## POST EPC MEMORANDUM

RE: PR-2018-001560, SI-2022-02414-Hoffmantown, Site Plan – EPC

Re: Response to Conditions of Approval – SI-2022-2414, Site Plan – EPC

**THE ESTATES AT ACADEMY  
HARPER CROSS SECTIONS**

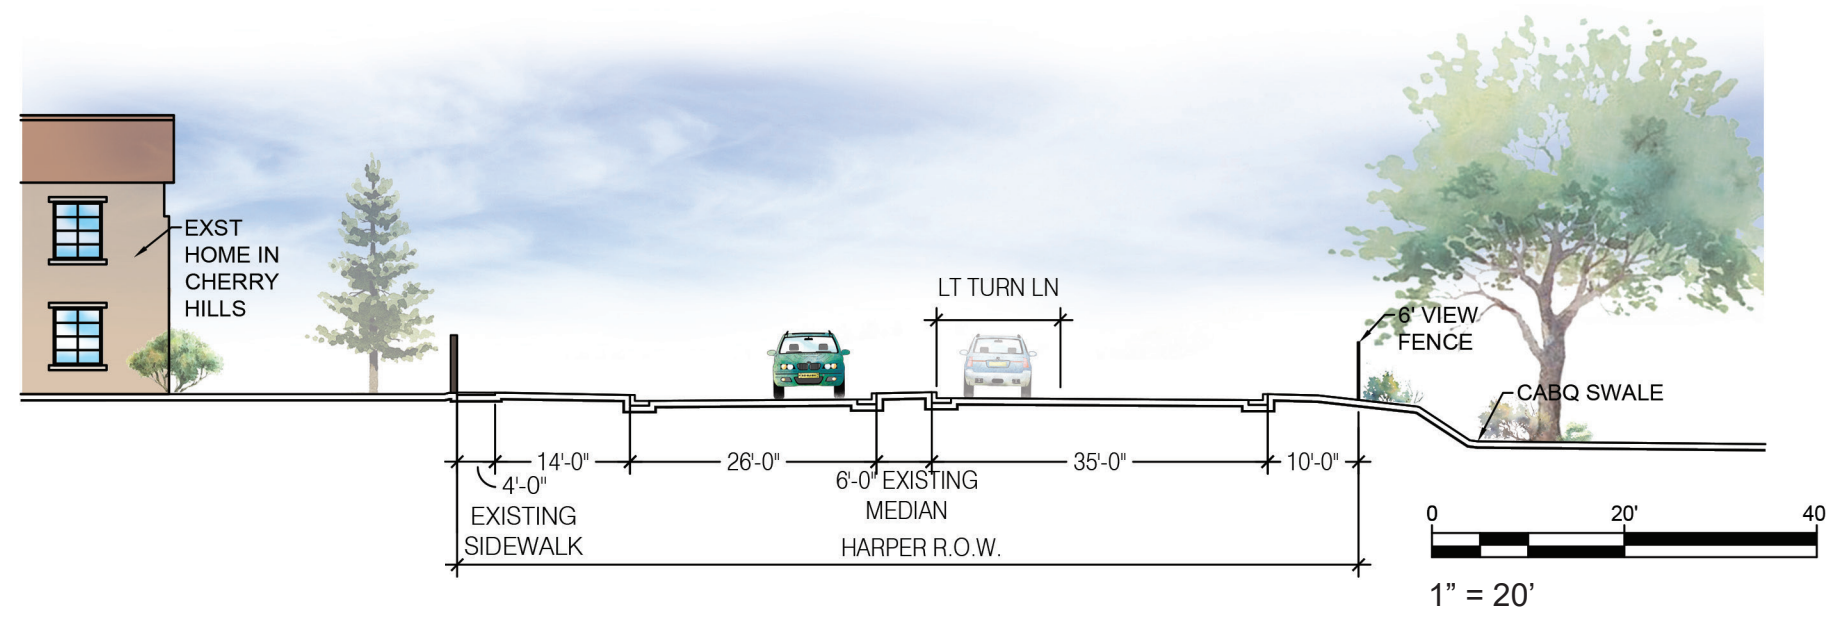
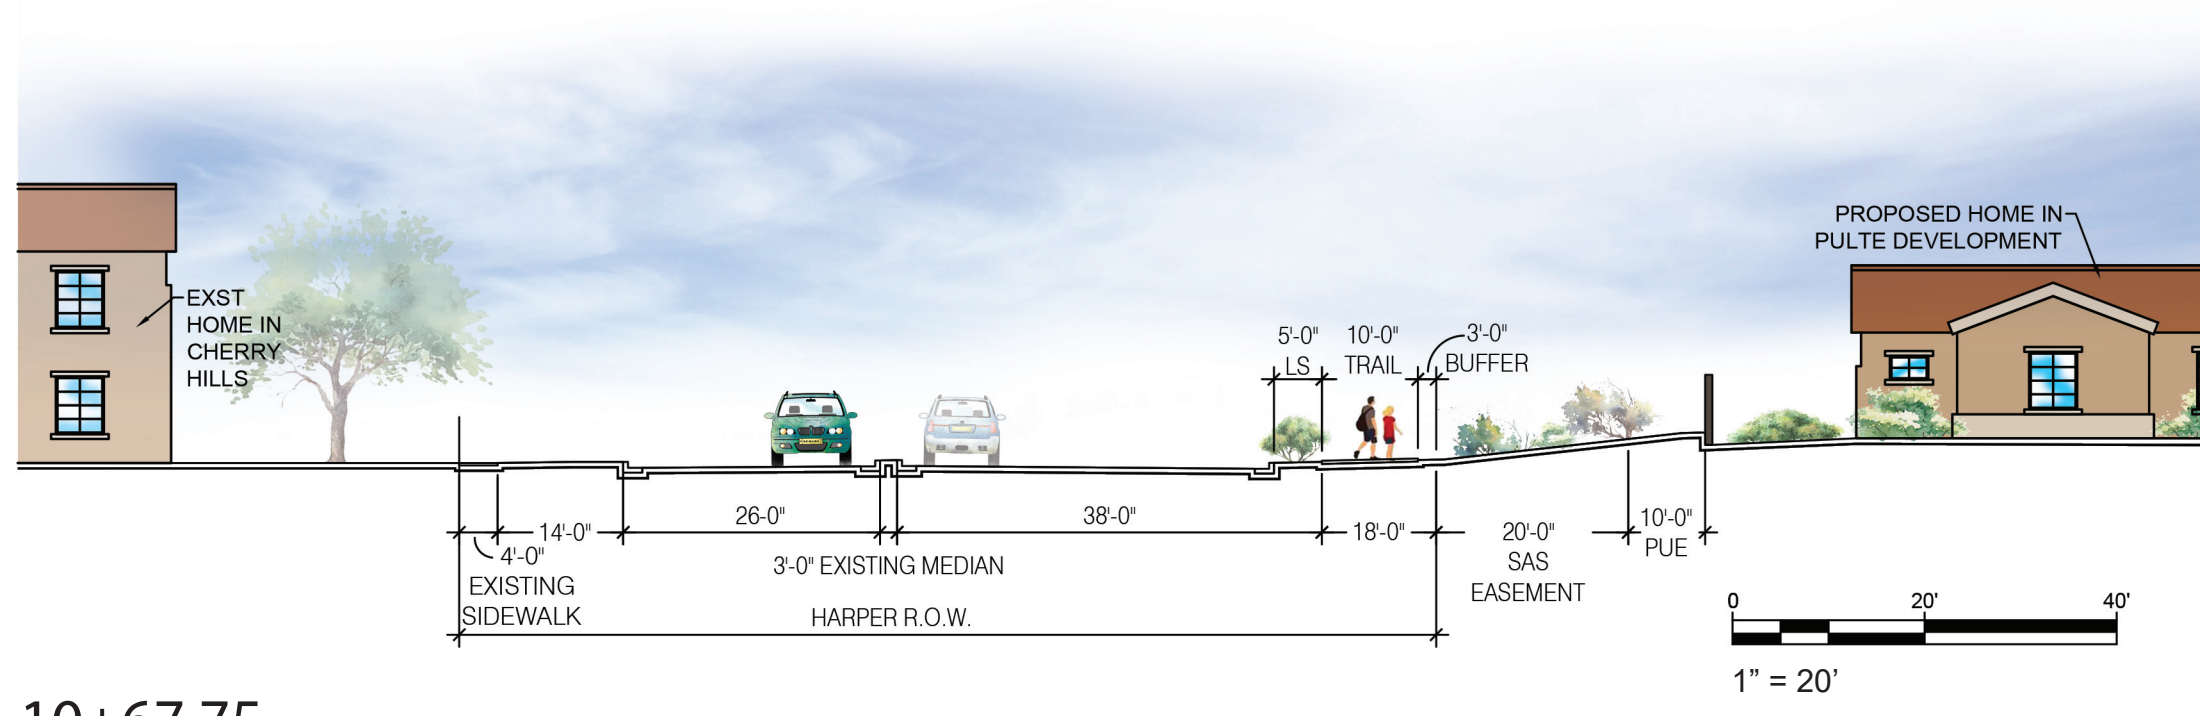
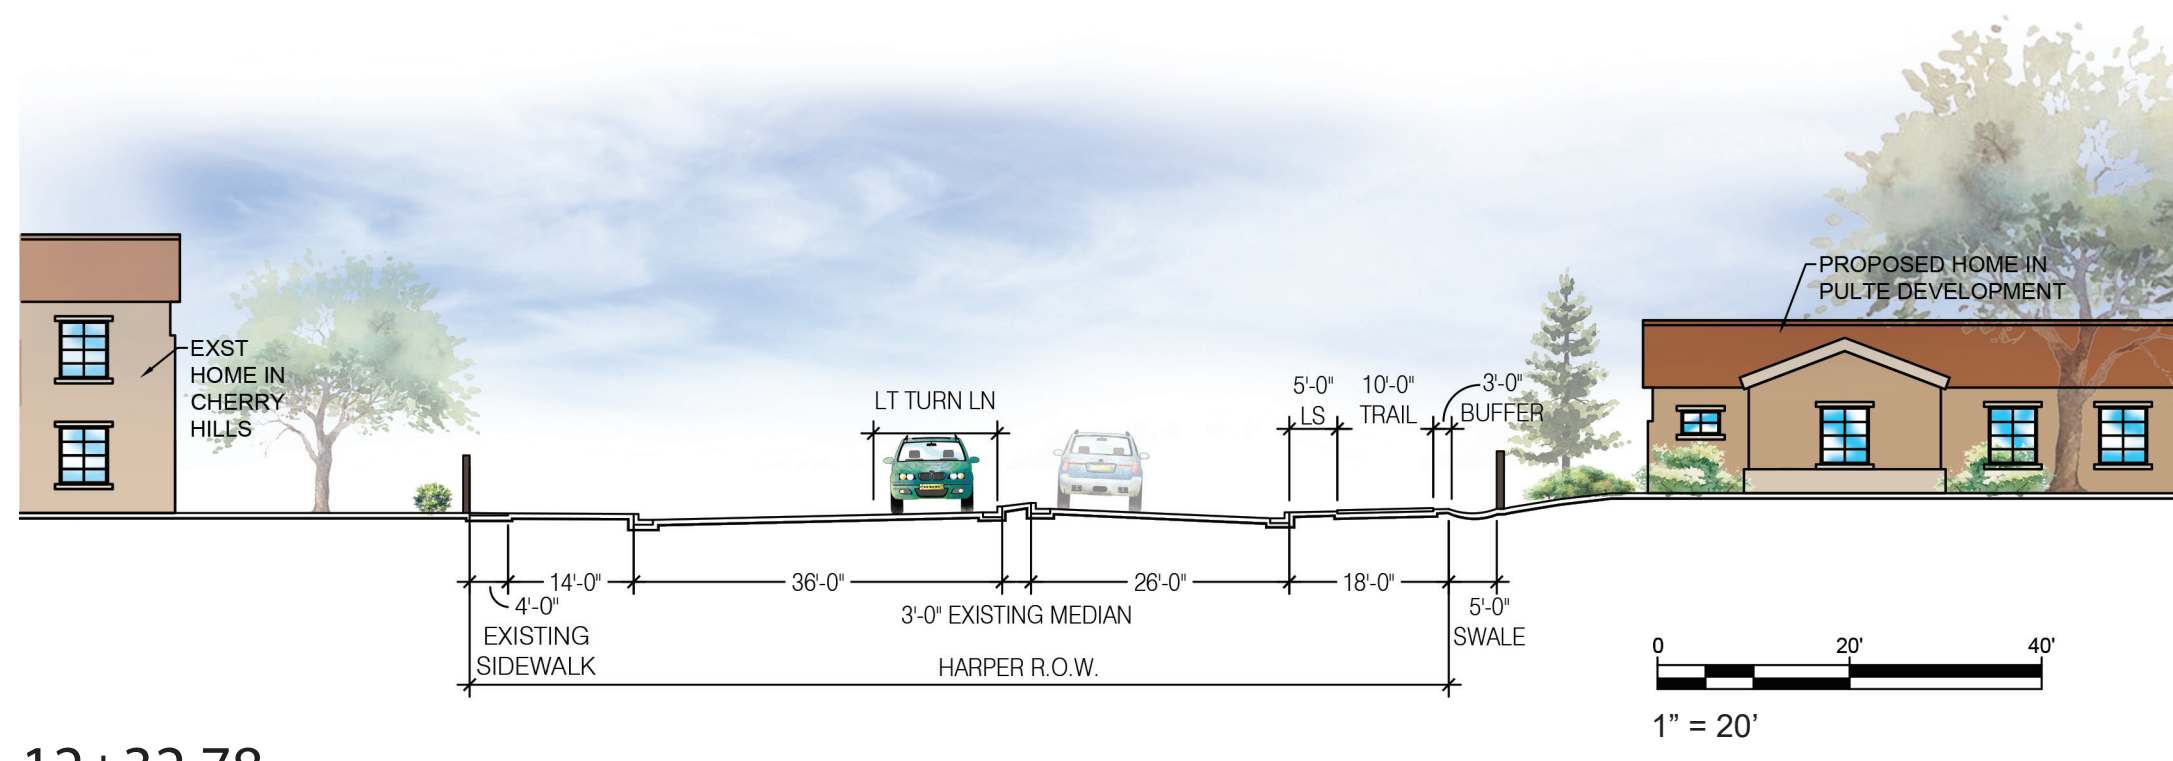
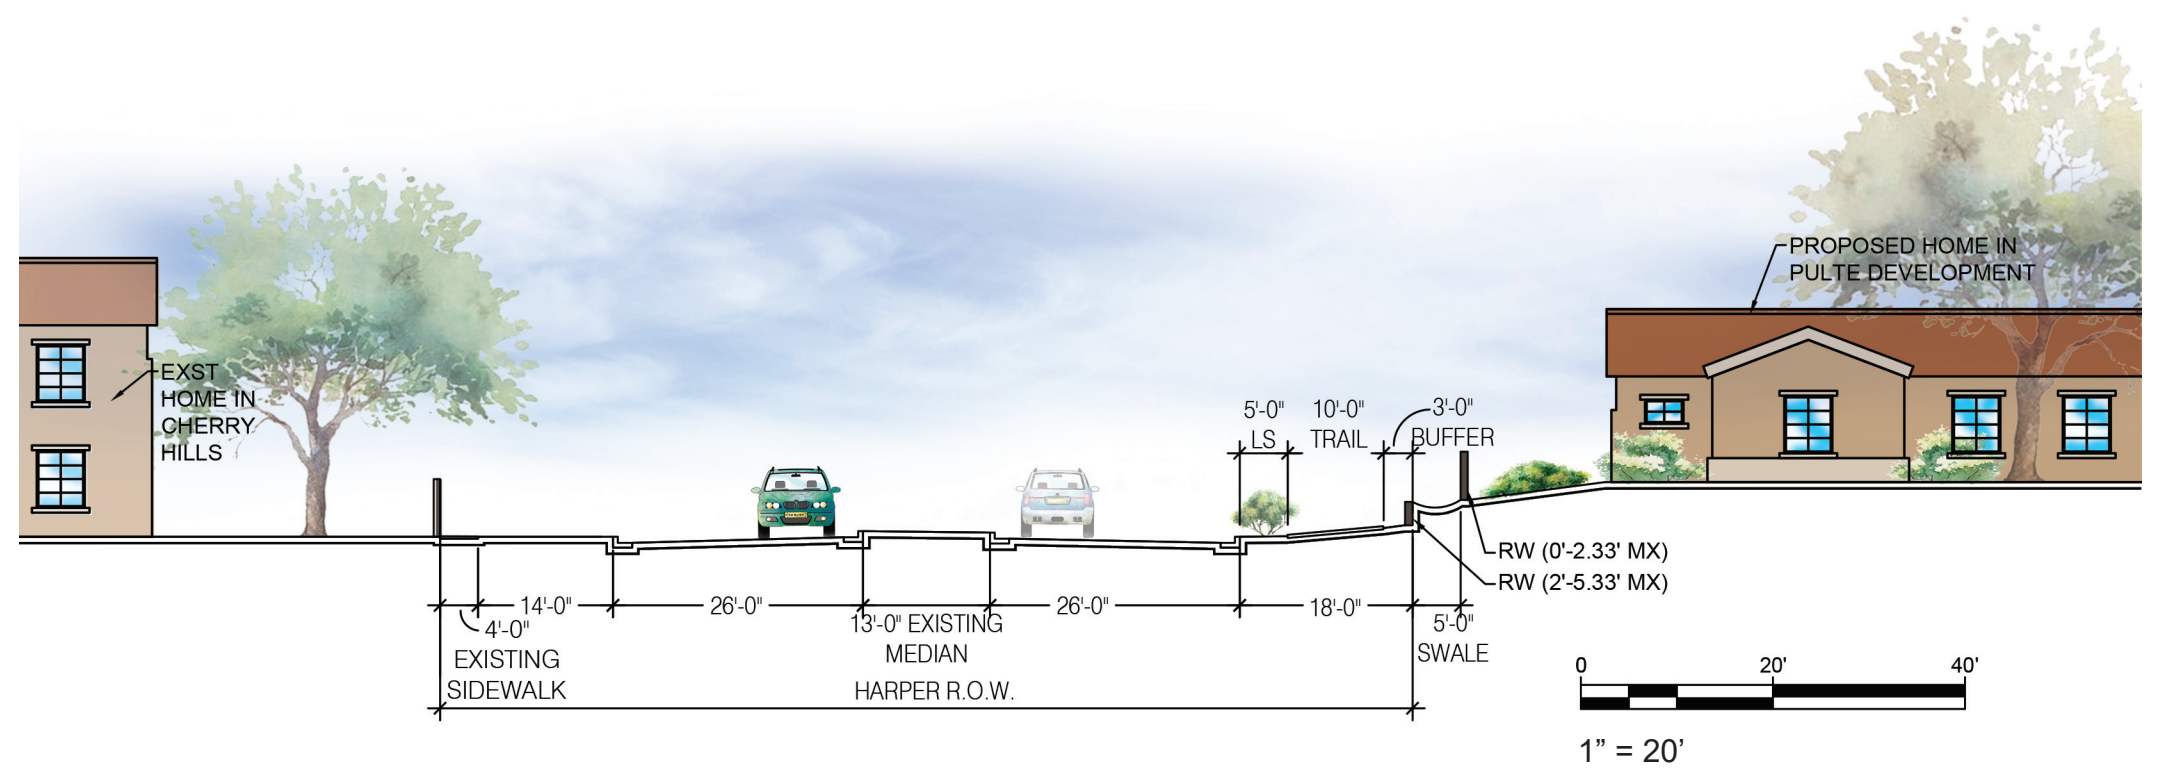
- d. A scale shall be added to the sheet with the cross sections.

Applicant response: Added a scale to the cross-section sheets.
